PIR comments - Sydney Metro City and Southwest (Sydenham to Bankstown)

Ref: SSI 8256

Thank you for the opportunity to review and comment on the Preferred Infrastructure Report for the proposed Sydney Metro City and Southwest (Sydenham to Bankstown) Project.

Figure 98: Marrickville Station – indicative layout of key design elements

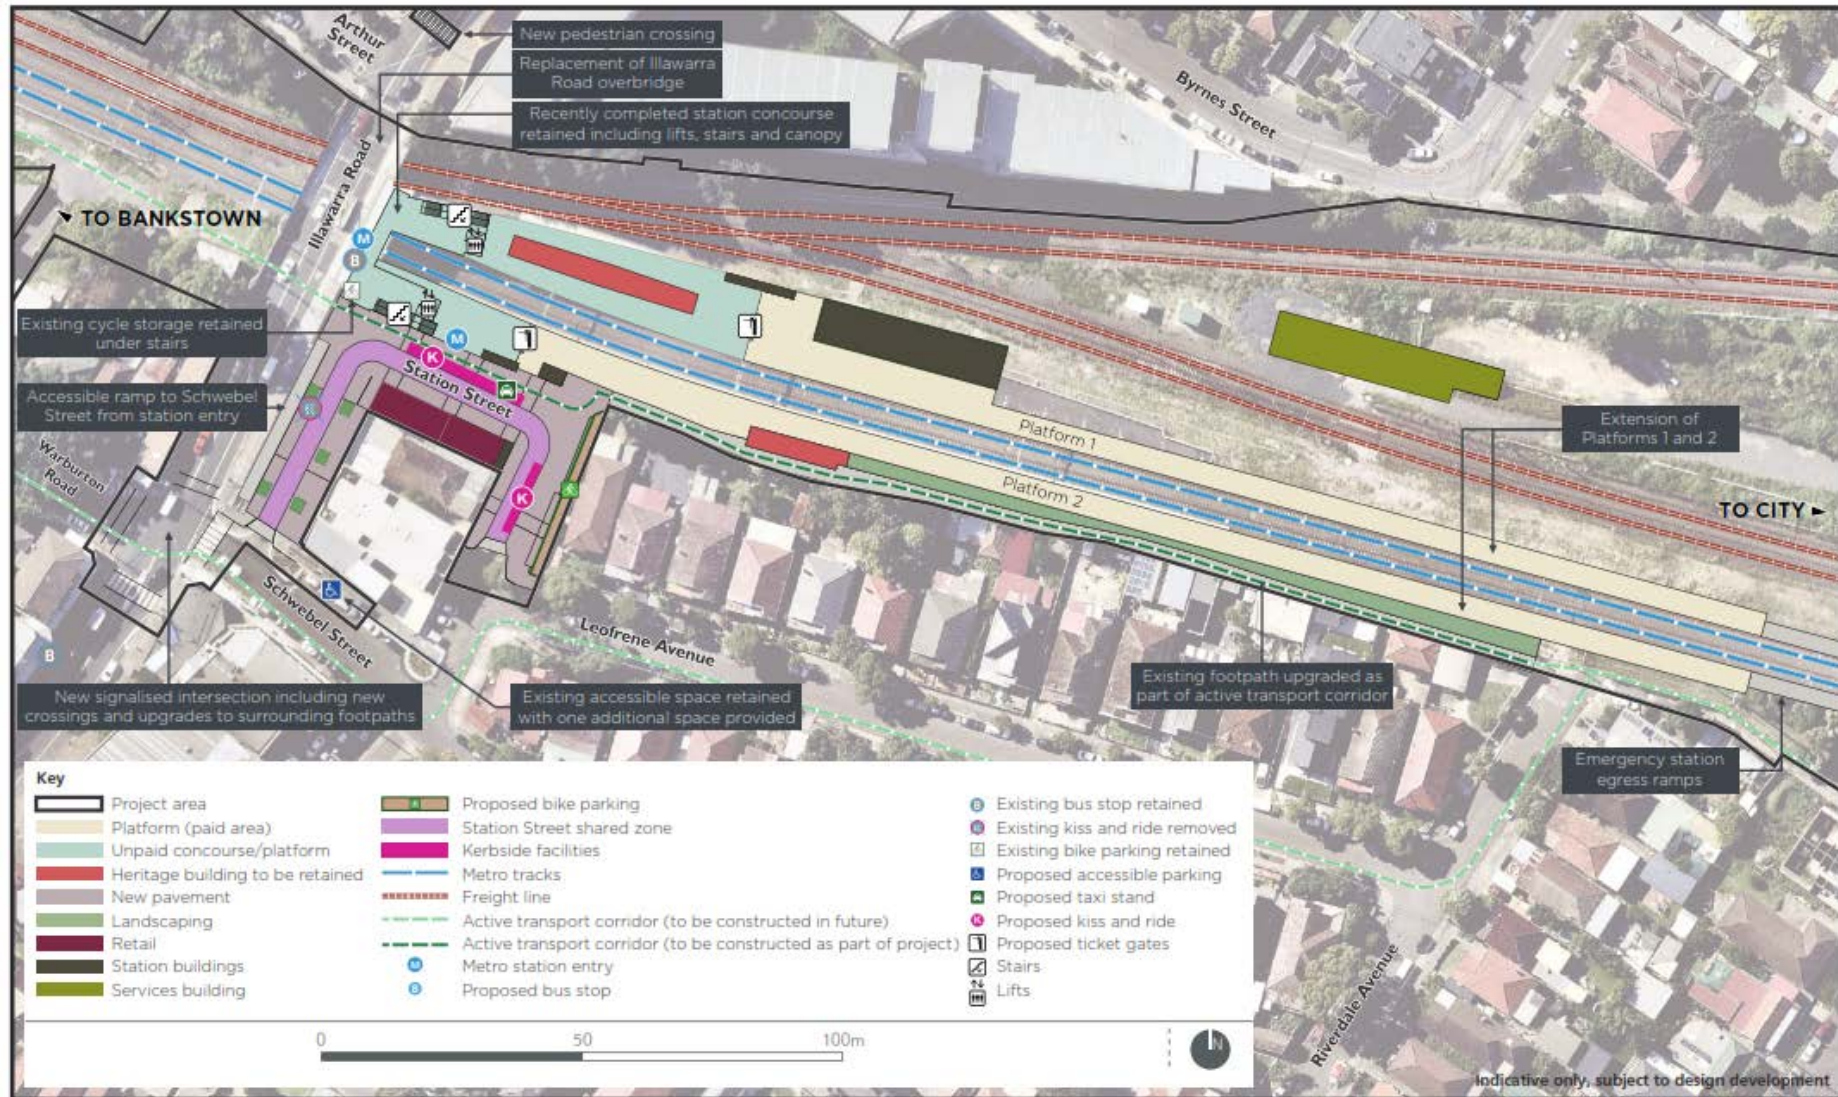
The following should be considered if drainage works are to be undertaken at Marrickville station:

- The review of discharges to the Malakoff tunnel in minor flood events.
- Any proposal to pipe additional stormwater flows from the southern side of Marrickville Station to the northern side of the railway line will have a negative impact which will cause flooding to the low-lying properties near the intersection of Byrnes and O'Hara Streets.
- The overall flood management plan should investigate a controlled overland flow path along the southern side of the railway line at Station Street.
- Water quality improvement measures should be incorporated into the design of the basin.
